City of Portland, Maine - Building or Use Permit Application

Job No: 2012-06-4270-SIGN	Date Applied: 6/6/2012	CBL: 266- A-003-001		
Location of Construction: 55 RIVERSIDE ST	Owner Name: ENERGY NORTH GROUP	Owner Address: 1700 SHAWSHEEN ST FLOOR 2 TEWKSBURY, MA 01876	Phone: 207-443-2192	
Business Name:	Contractor Name: NH Signs /Rick Donnelly	Contractor Address: 60 Old Derry RD LONDONDERRY NH 03053	Phone: (603) 437-1200	
Lessee/Buyer's Name:	Phone:	Permit Type: SIGN - PERM - Signage - Permanent	Zone: B-4	
Past Use: Gas Station/Convenience Store	Proposed Use: Same – replace pump signs on five pumps – permit not required, but signs must be 1 sf or less	Cost of Work:	CEO District:	
		Fire Dept: <input type="checkbox"/> Approved <input type="checkbox"/> Denied <input type="checkbox"/> N/A Signature:	Inspection: Use Group: Type: Signature: <i>N/A</i>	
Proposed Project Description: replace 5 pump signs		Pedestrian Activities District (P.A.D.)		
Permit Taken By: Brad		Zoning Approval

Re: 1199 Congress Street – 078 A001 – B-1 – Permit #2102-06-4167 & 55 Riverside Street – 266 A003 – B-4 Permit - #2012-06-4166

SIGN 7

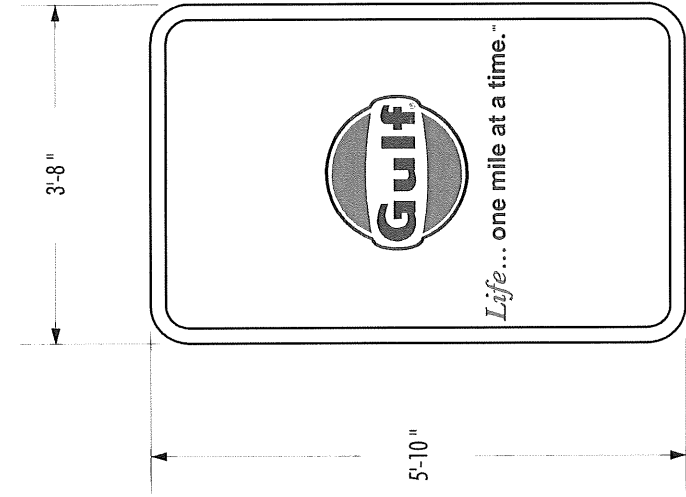
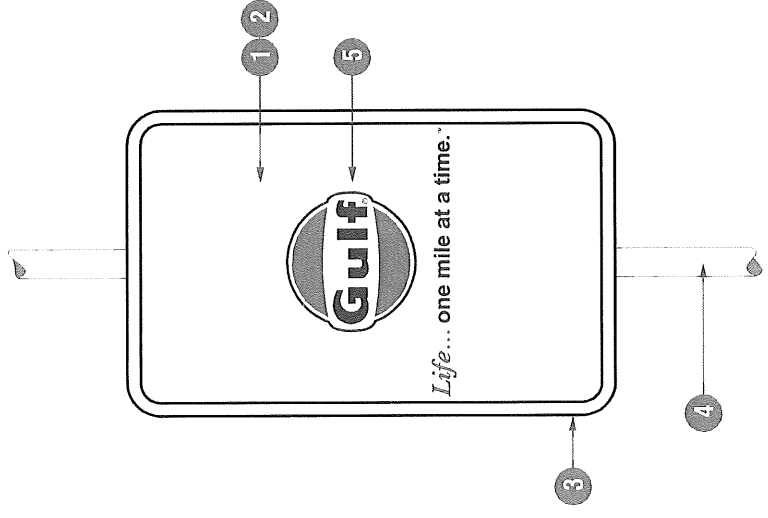
- The three Energy North signs are legally nonconforming but they are the same size as what has been permitted before, so they can be permitted.
- The two panels can be replaced in the pylon sign, but I question the dimensions that you have given. They have changed slightly from the sign permit for the pylon sign that was issued last year (2011-12-2856).
- Two canopy signs are allowed but the maximum square footage per sign is 20 sf. Each proposed canopy sign is 48sf.
- The 70" x 44" Clipper Mart sign on the light pole was not permitted. It cannot be replaced. Only one freestanding sign is permitted per lot.
